From: [Holly Erdman](#)
To: [Jesse Cox](#)
Cc: [Kelly Bacon \(CD\)](#)
Subject: Hein SP-20-00004
Date: Friday, August 7, 2020 11:18:19 AM

These comments are for the above proposed short plat. The applicants are proposing a 4 lot short plat – lot 1 - 5.91 acres, has an existing house, drainfield and well locations are unknown, lot 2 – 6.72 acres is vacant, lot 3 – 7.26 acres has an existing house, drainfield and well locations are unknown and lot 4 – 30.09 acres is vacant land. They are proposing individual or shared wells and individual drainfields.

Well location

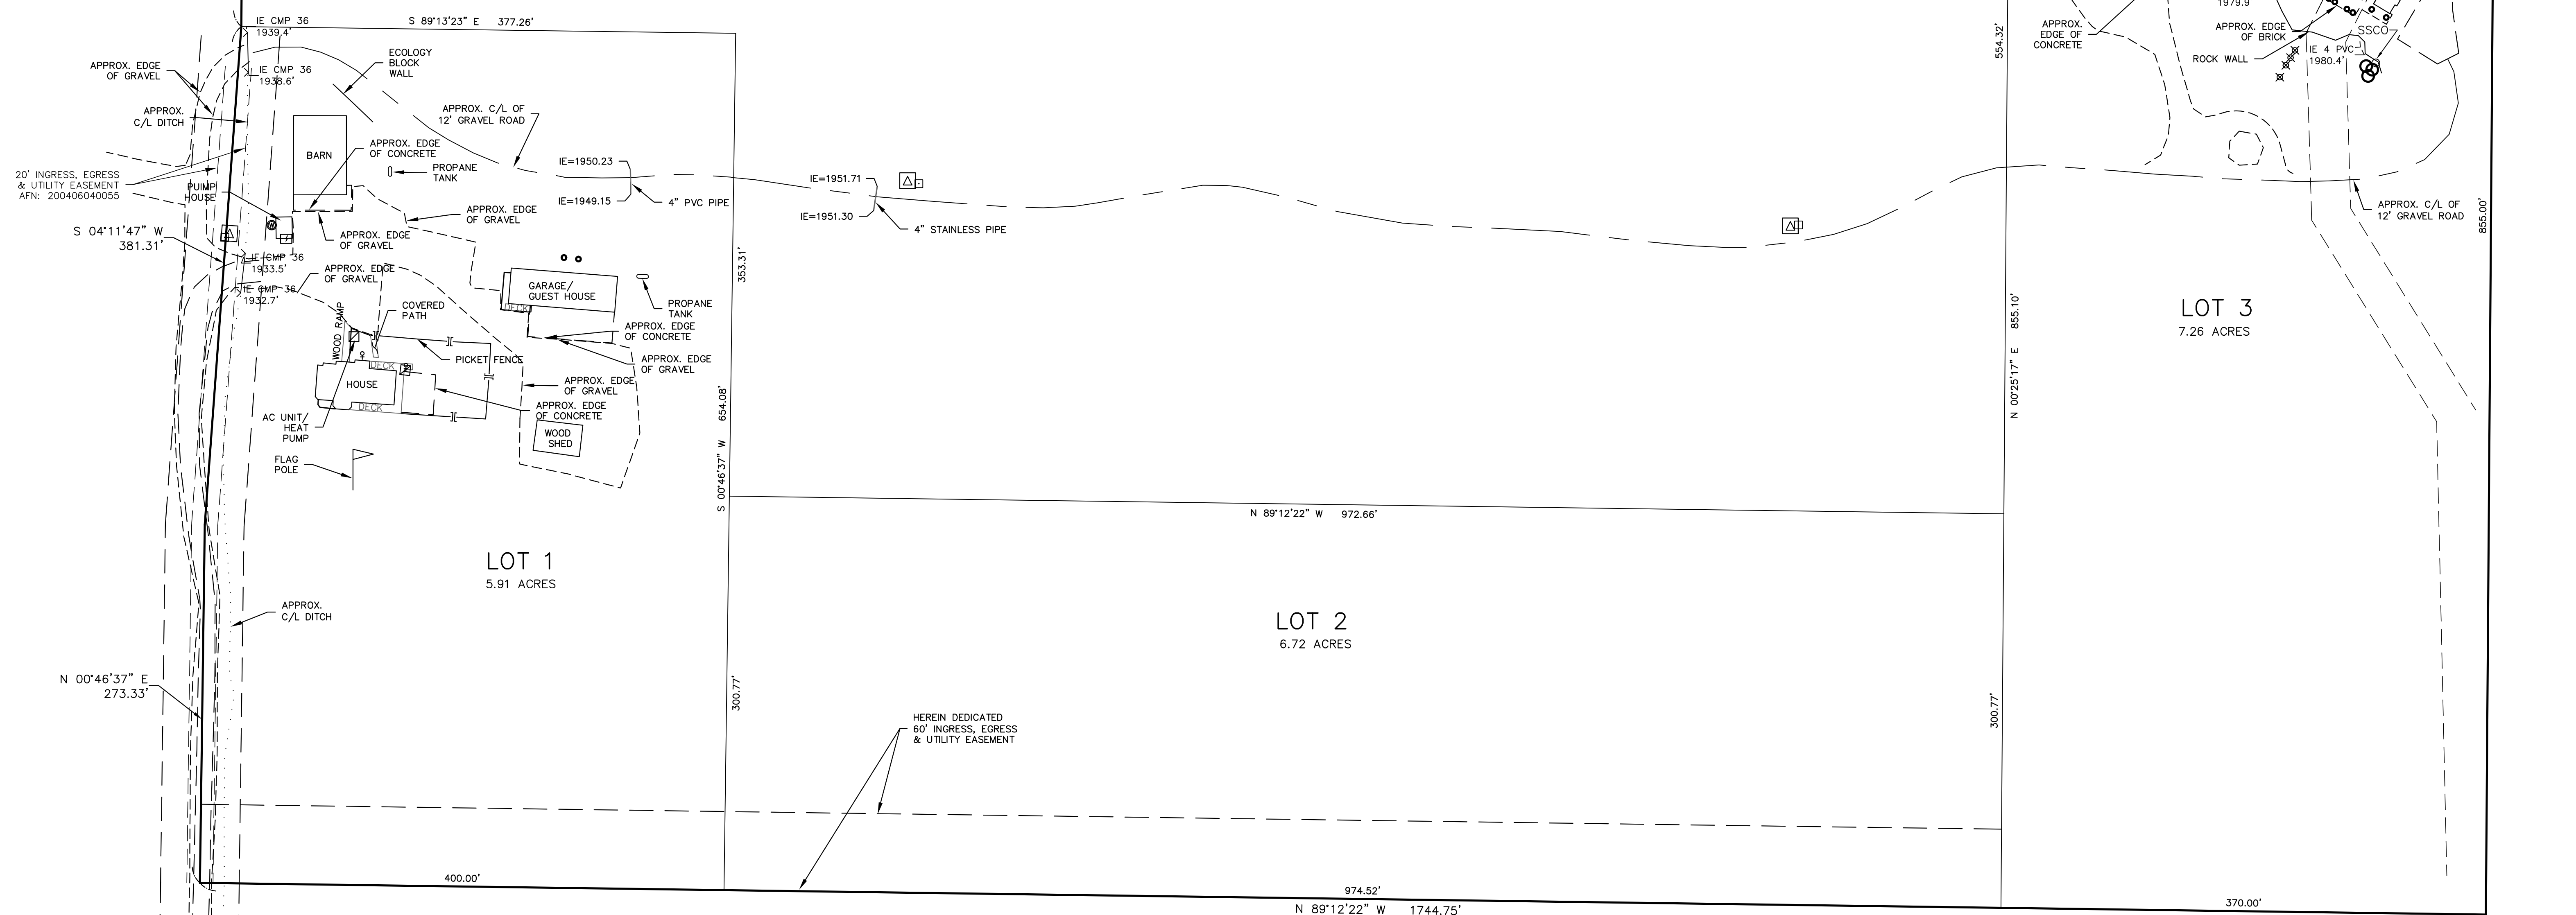
I have asked Kelly Bacon for additional information on the locations of the wells and drainfields on lots 1 and 3 so hopefully this information will be coming soon to enable us to comment in a timely fashion.

AIRPORT ROAD SHORT PLAT APPLICATION

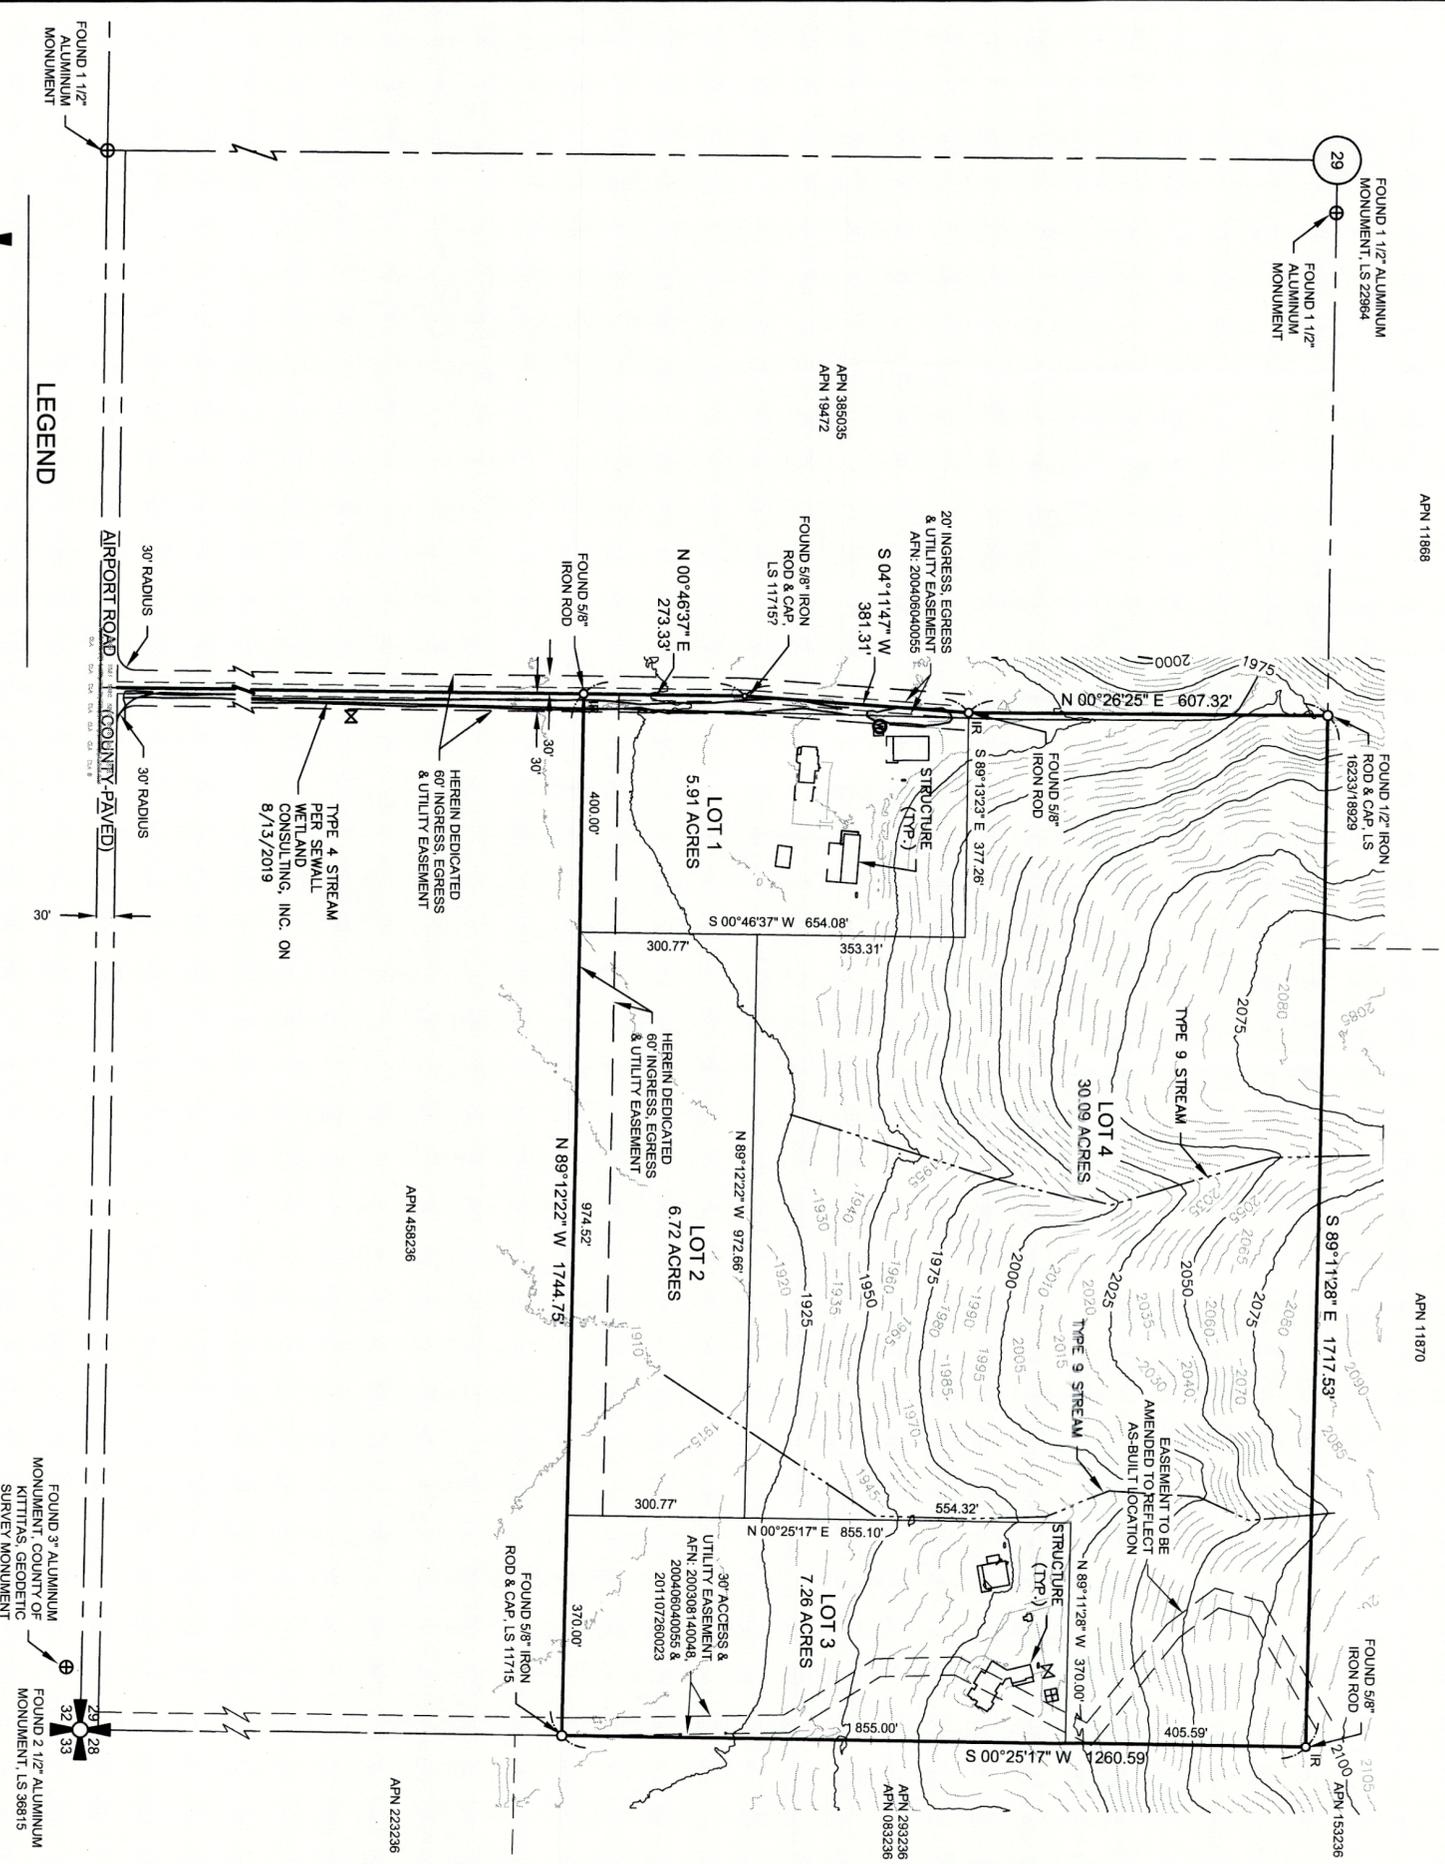
Prior to final plat approval we need a soil log performed on lots 2 and 4 and a well log and water rights for lots 2 and 4. If shared wells are to be utilized, the wells must be located a minimum of 50 feet from proposed property lines and a signed, notarized and recorded shared water user's agreement for each shared well must be submitted to our office prior to final plat approval.
